KITTTITAS COUNTY COMMUNITY DEVELOPMENT SERVICES

February 25, 2020

Subject: Shoreline Exemption Permit (SX-20-00004) - Request for Additional Information

SITE PLAN
2014-034

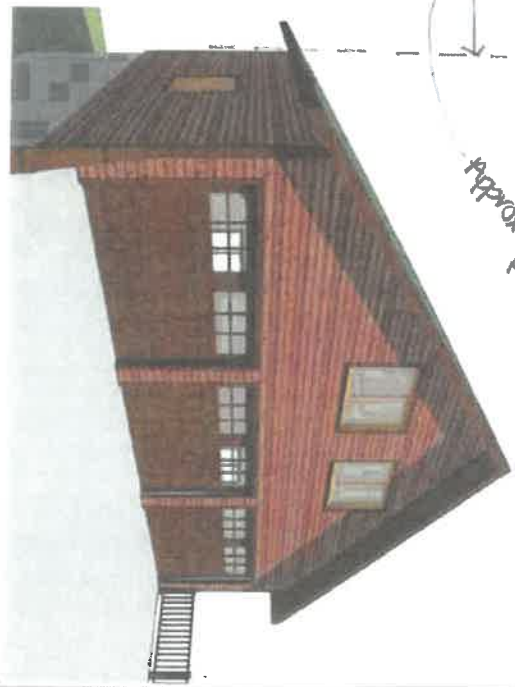
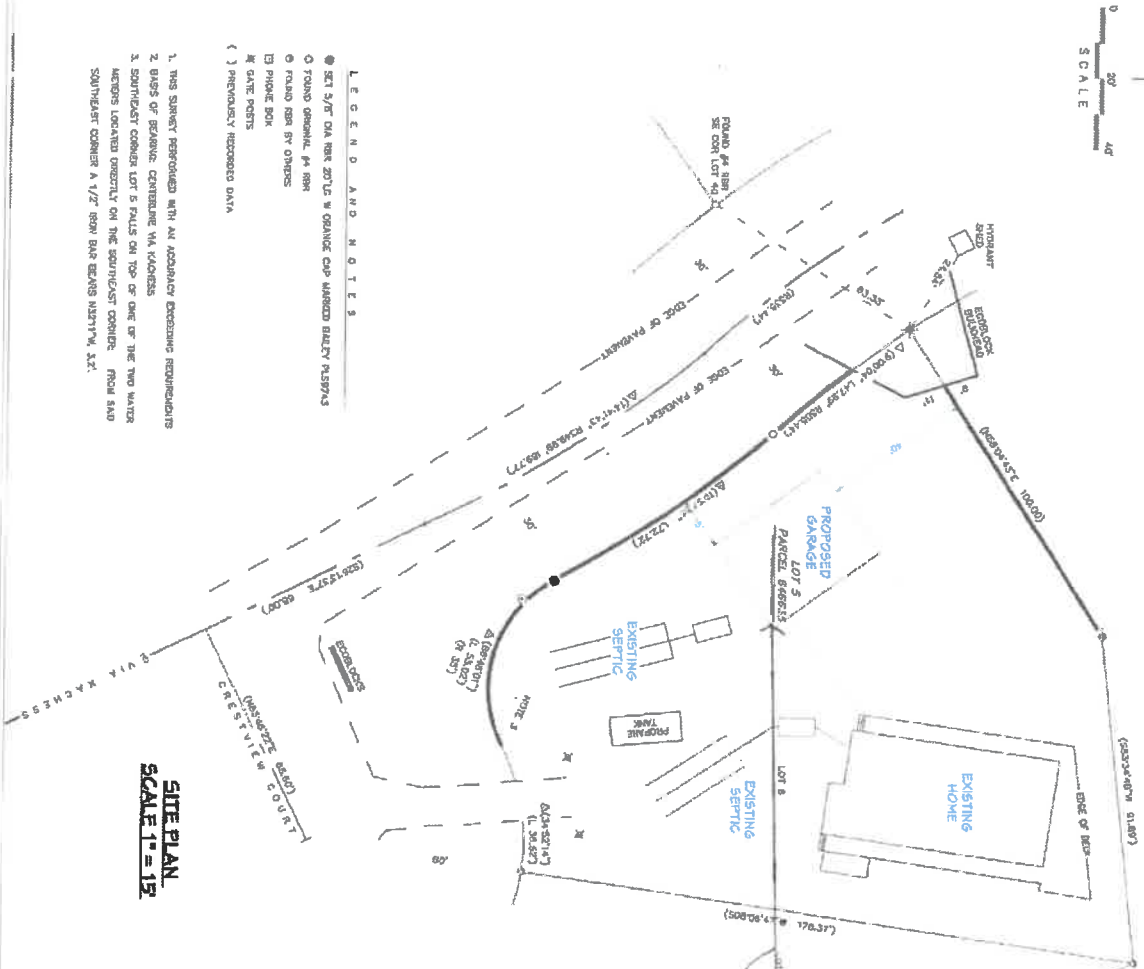
1. Updated site plan showing the following:
 - a. Clearly identified Ordinary High Water Mark (OHWM) of Kachess Lake
 - b. The 115' construction setback from the OHWM or the distance from the proposed structure to the OHWM.
 - c. A profile view showing the horizontal distance from the OHWM to the edge of the new structure.

Please update your site plan accordingly.
